Objection to Airly Colliery modification 3 – (extending the 162/91 consent for a year) due to *inappropriate consent conditions*

By the Colo Committee

Page 11 of the June 2014 environmental assessment states that modification 3 would extend the life of the existing consent to 31 October 2015, implying no modification of inappropriate consent conditions. The proposed modification would include a mine method and design that allows ‘Full extraction in areas outside Environmental Protection Zones with supercritical void widths’ and ‘**maximum subsidence of 1.8 m**’ (page 11, Section 3.1 mining under the proposed modification). **Subsidence of 1.8m is totally unacceptable must be overturned by any extension of development consent under Modification 3.**

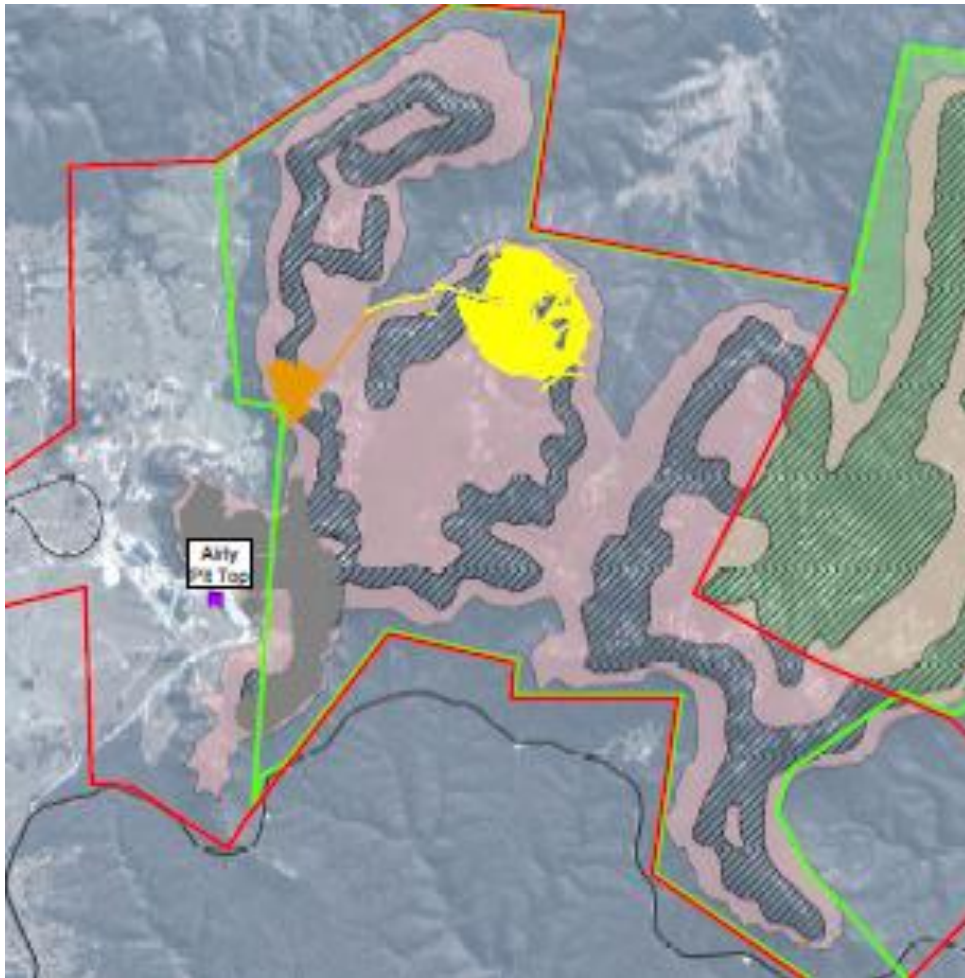
Figure 5 of the EA shows that the bulk of the SCA is not in the so-called ‘protection zones’ (see below). More than three quarters of the mesas will be subsided by 1.8 metres. Where this has occurred elsewhere in pagoda country with longwall mining, this has caused hundreds of cliff collapses and cracking of pagodas (e.g. Angus Place and Baal Bone Collieries).

Figure 5 (above) is deliberately kept vague and at low resolution in the proposal document to hide the enormity of the areas that will be subsided by a staggering 1.8 metres. However, since the Colo Committee knows the area very well, we point out that they will threaten with collapse and cracking. Below shows a series of Google Earth snapshots. The Colo Committee has many slides of most of these areas but does not have digital scans of these, now in the short 2 week timespan have we been able to scan these. Hence I use snaps from Google Earth. It should be pointed out that Google Earth always makes topography look flatter than it actually is. The slopes shown are thus actually steeper. Some key areas in the 1.8 metre subsidence (= collapse and cracking) zone are:

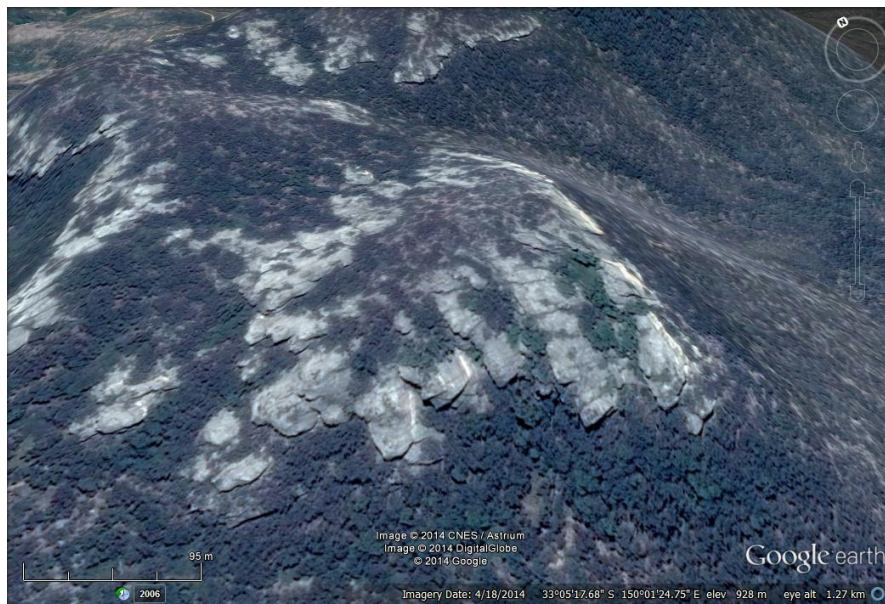
- the smooth pagodas shown below near mount Torbane (visible from Mudgee highway),

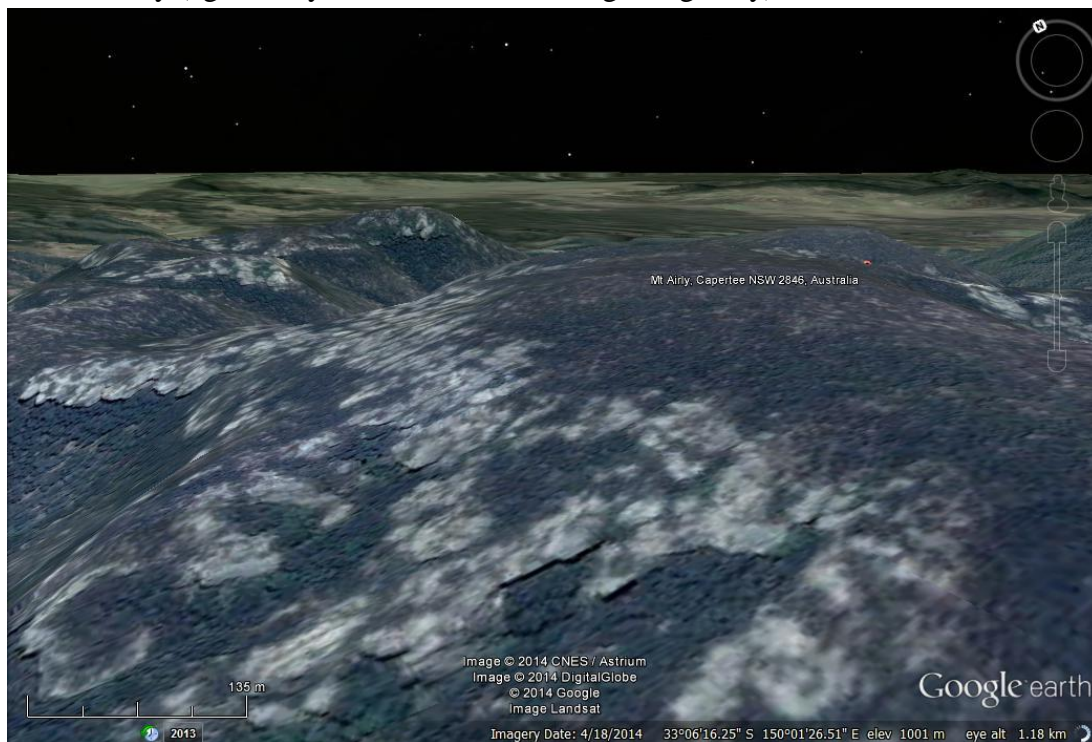
- the vast majority of the superb steeply-sloped pagoda band on the west of Mount Airly (again very visible from the Mudgee highway),

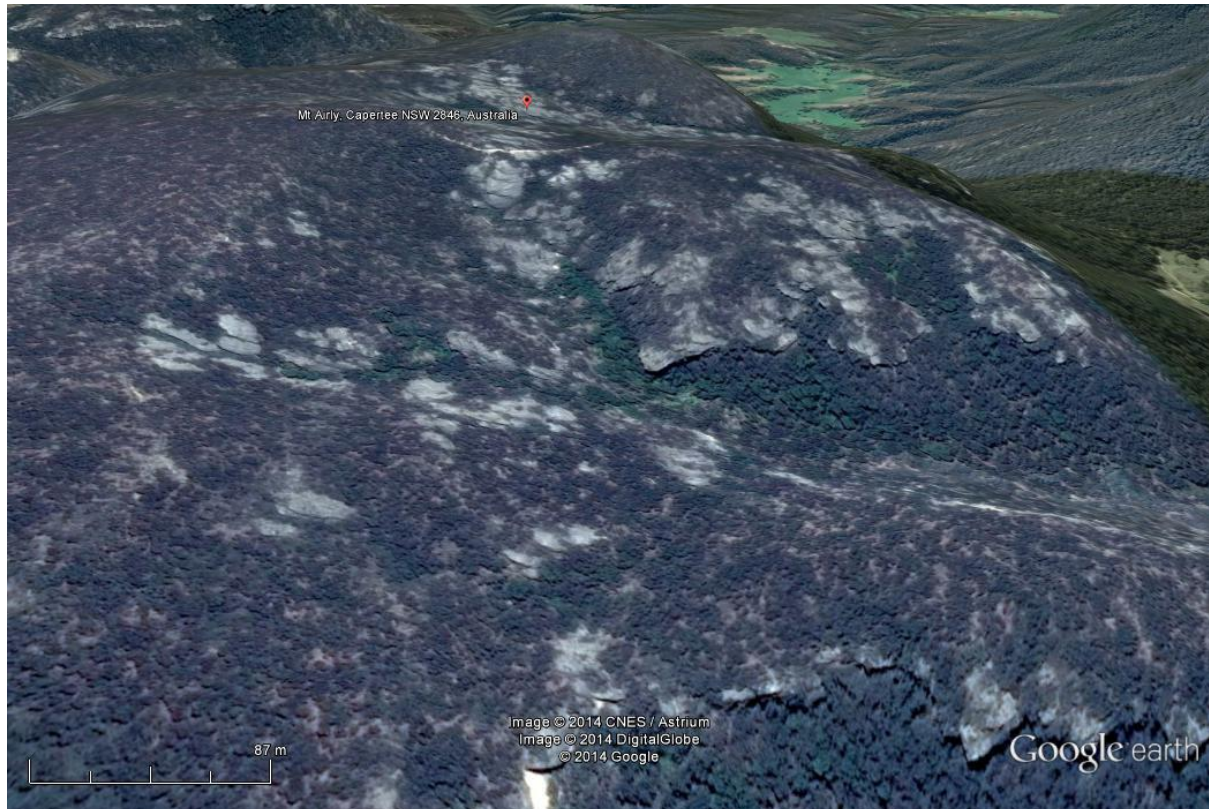
- very steep internal cliff-lines on the east side of Mt Airly (note the tall cliff with shadow is in the 1.8 metre subsidence zone and will almost certainly collapse)

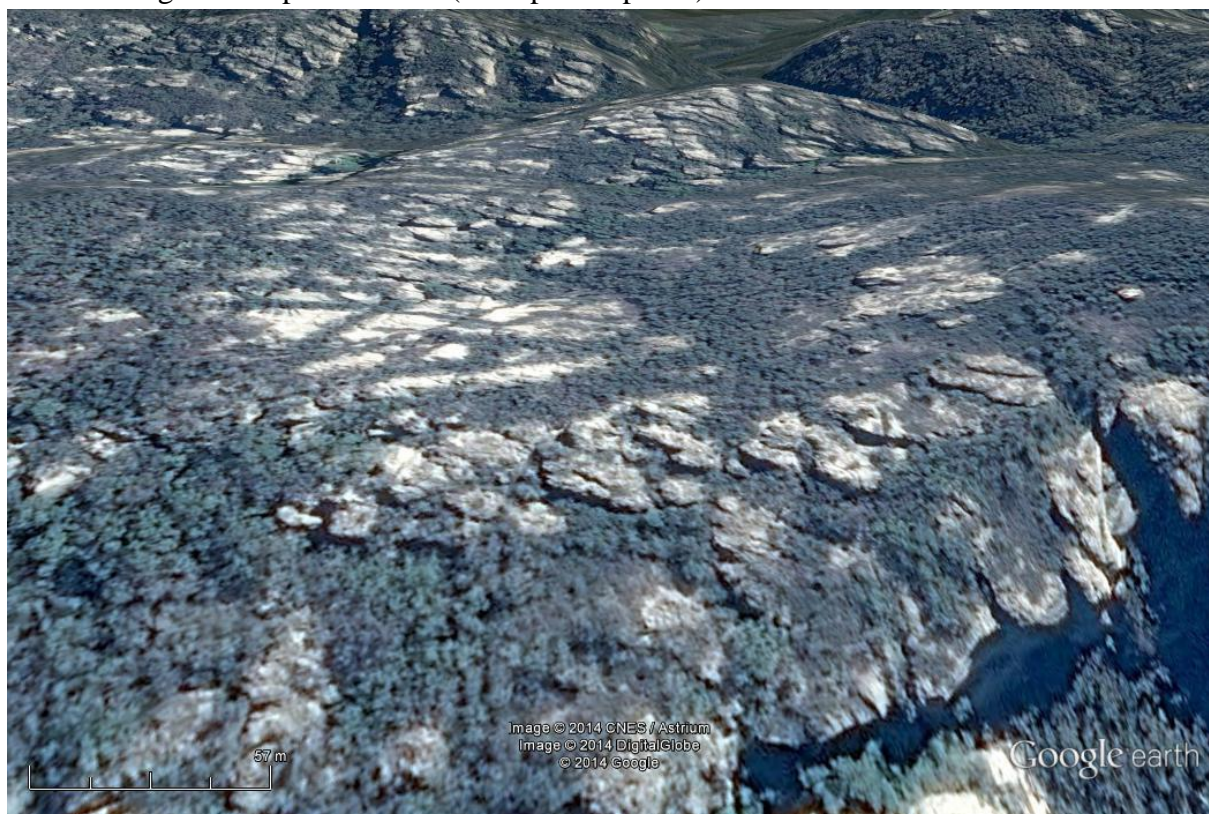
- pagodas east of Genowlan Mountain trig, note cliffs and caves shown in shadow in Google Earth photo below (front part of photo)

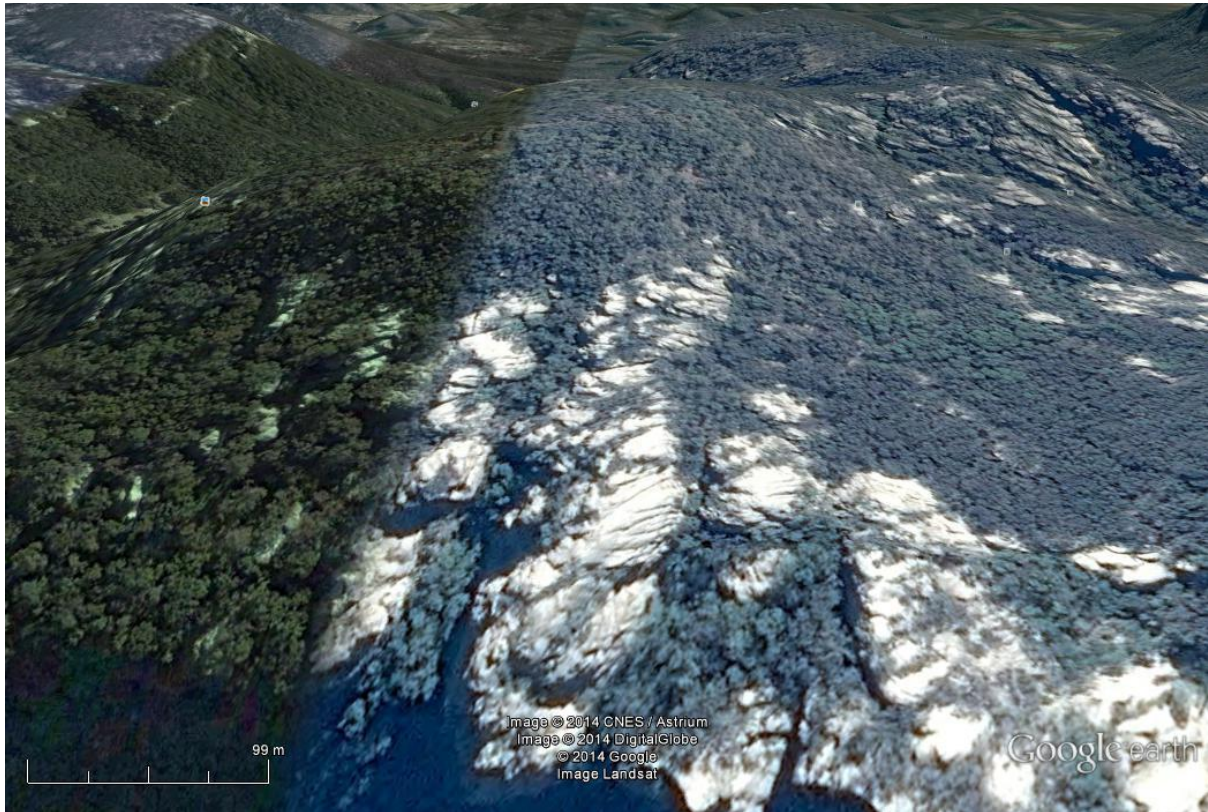
- pagodas west of 'Pappy's Pass' (where the road from Col Ribaux's property emerges on the south of the plateau). Note the deep canyon marked with trees in centre-photo that passes through the pagoda complex and will likely be shattered and collapse.

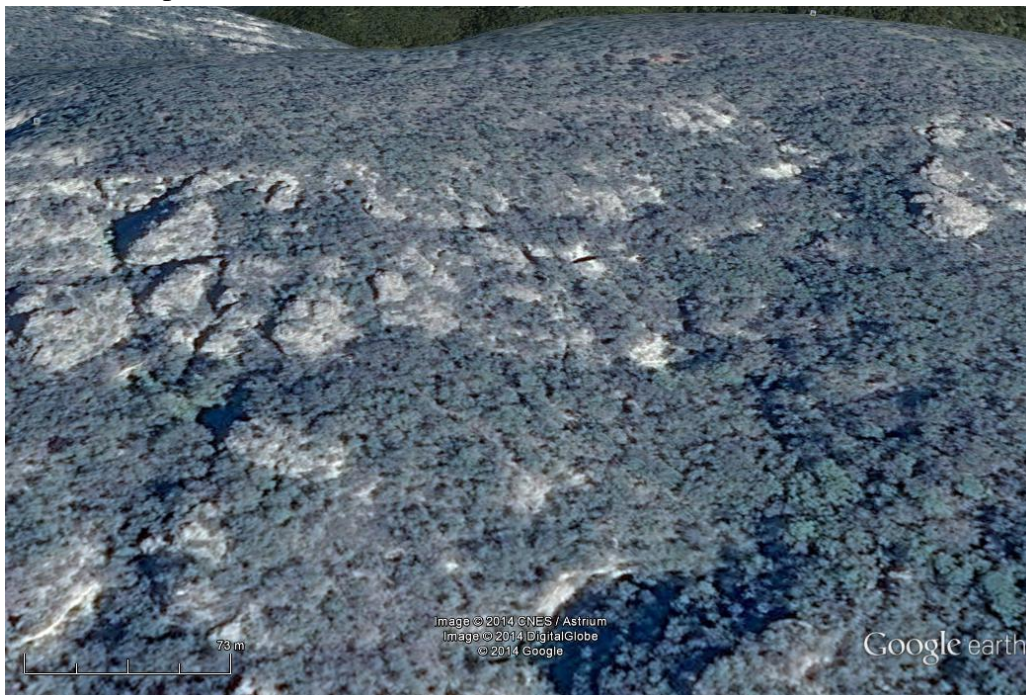
- pagodas on the south-east side of Point Hatteras which drop around 50 metres into a creek on the left of photo (extremely likely to collapse). Note also the tall pagodas undercut by caves and slot canyons on the left of photo. These are almost certain to collapse with 1.8 metre subsidence.

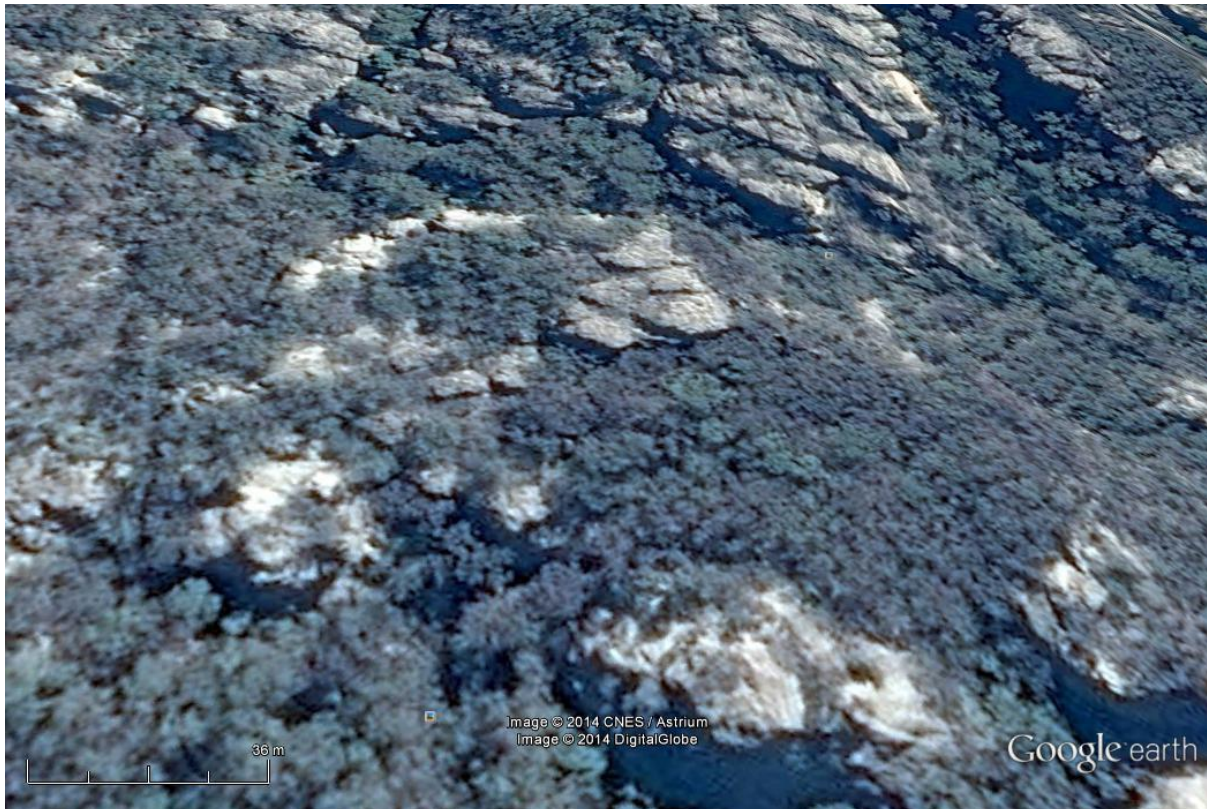
- pagodas to the north-west of the Grotto (centre photo) with cliffs and probably overhangs that will collapse.
